File No: R/2014/17/E
Our Ref: 2016/503179

SSD 5824 MOD 2 - One Carrington Street Redevelopment
Section 96 Modification Application to include stratum subdivision to the proposal

GEORGE STREET

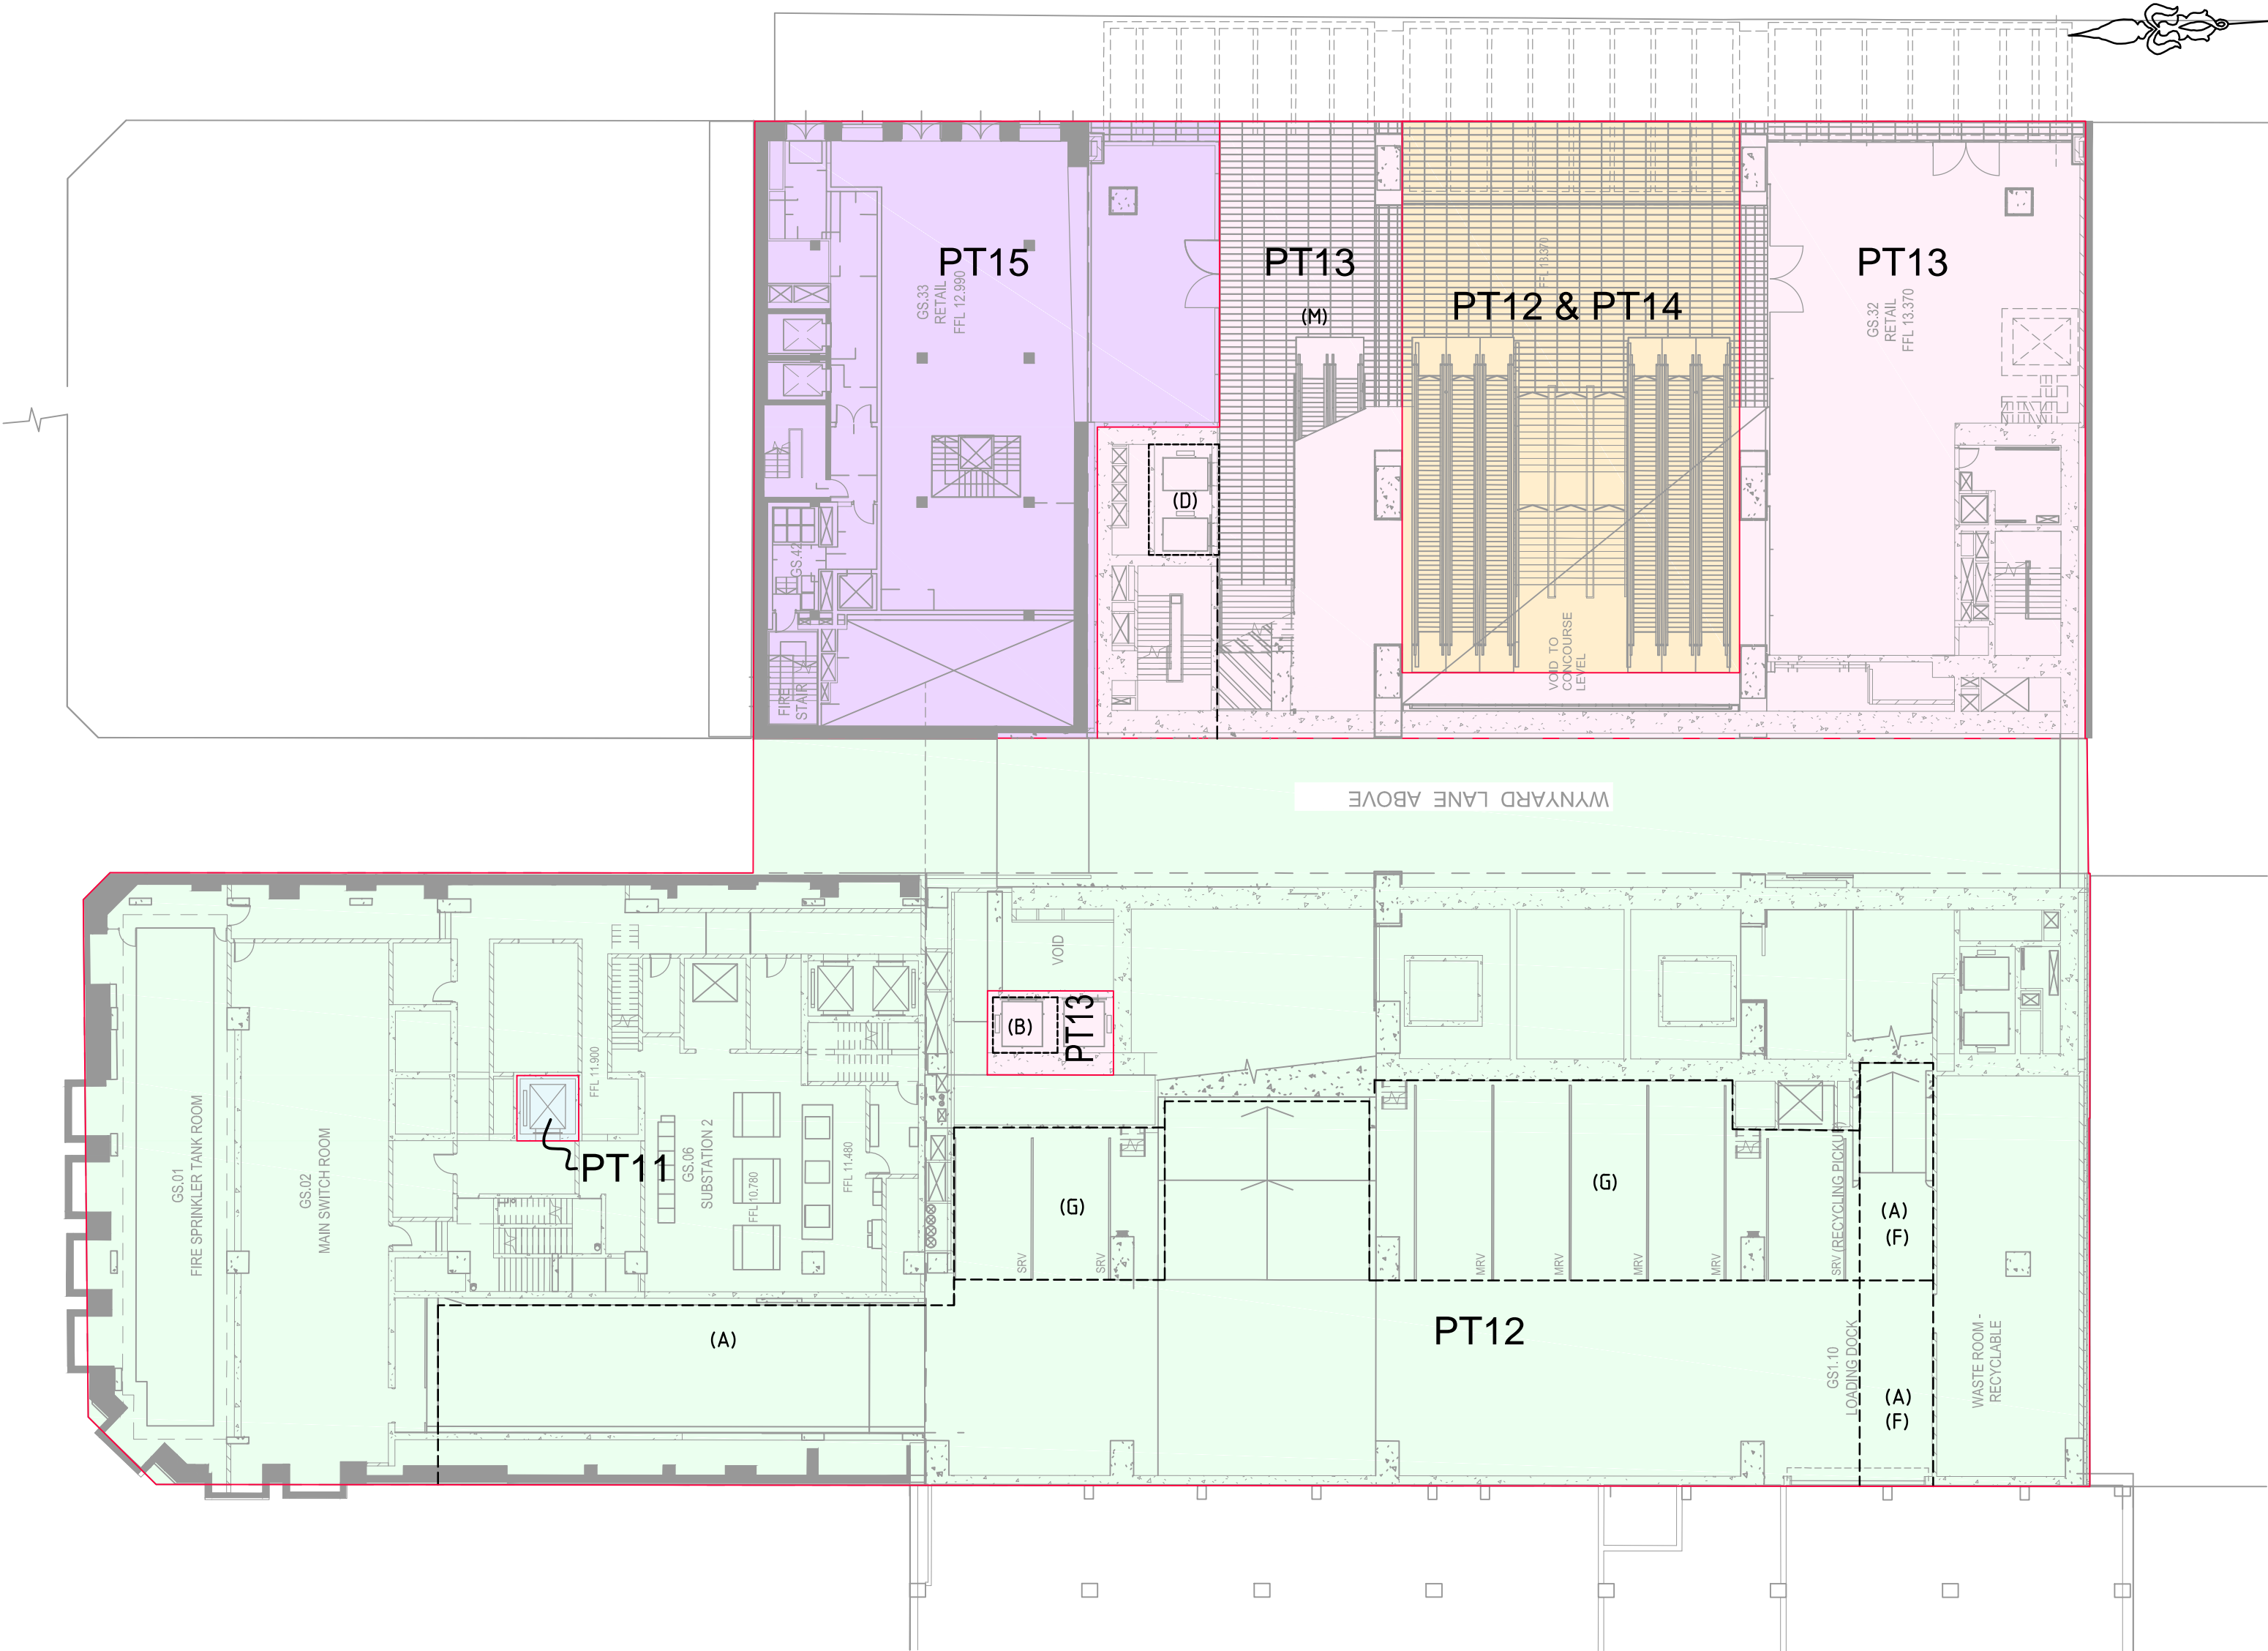
1. the proposed Lot 16 (Road Lot) is not shown on the George Street Subdivision Plan (Sheet 5 of 12). This does not correspond with the approved floor plans dated 11 August 2016. Further, the services zone within the approved floor plan is limited in area.
2. The proposed subdivision plan shows Lot 12 (Commercial Lot) extended under more of Wynyard Lane than approved. This is not supported by the City and not reflected in the current determination.
3. An amended Subdivision Plan is necessary clearly showing Lot 16 (Road Lot) where no development works have been approved.
